Erection of 9 No. dwellings with associated access, parking, cycle & refuse storage & landscape design. This application is a Departure from the Development Plan & may affect the setting of a listed building.

Rear of Inglenook Hotel 253-255 Pagham Road Pagham

Thank you for your internet representation made on 1st August 2019 which has been recorded as '**an objection**' with the comments as follows:

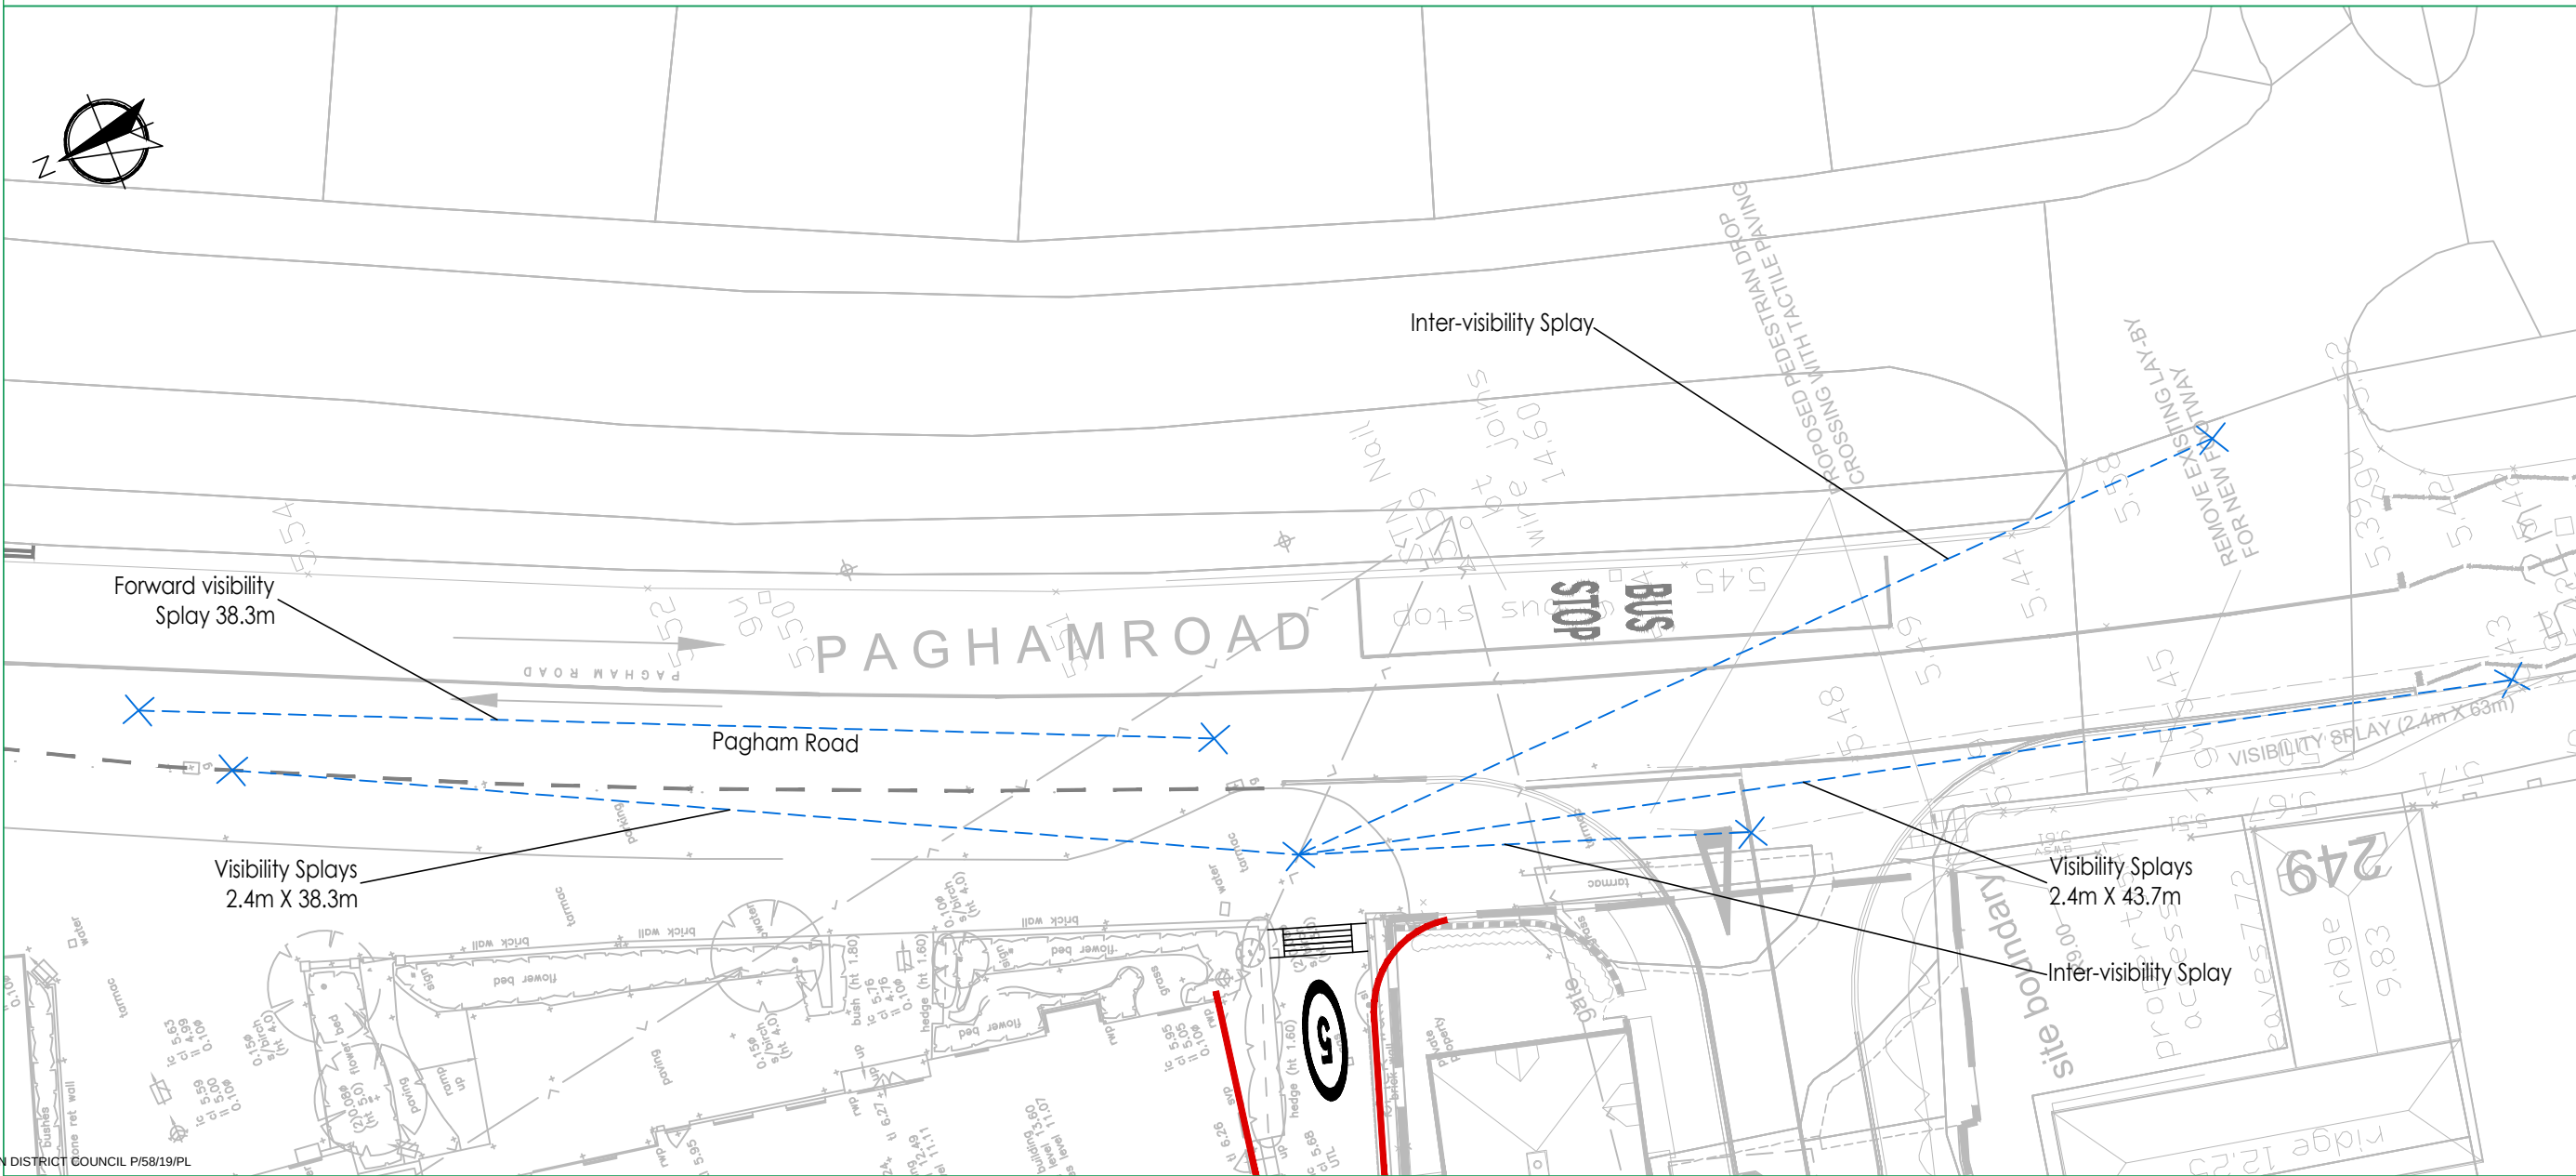
- 1: The overall width of the site as shown on the plan is misleading. The properties on the north side of the site will be much closer to the properties on Mill Farm Drive than suggested.*

- 3: There is no natural hedge/tree barrier to the proposed site, although it is shown to exist on the site plan.*
- 4: The site entrance on to Pagham Road will be very restricted, and cross a busy pavement leading to the only pedestrian crossing in the area, which in turn gives access to local shops. Visibility for vehicles exiting the development will also be severely restricted due to Inglenook delivery vehicles and customers cars parked in the lay-by to the left at all times.*
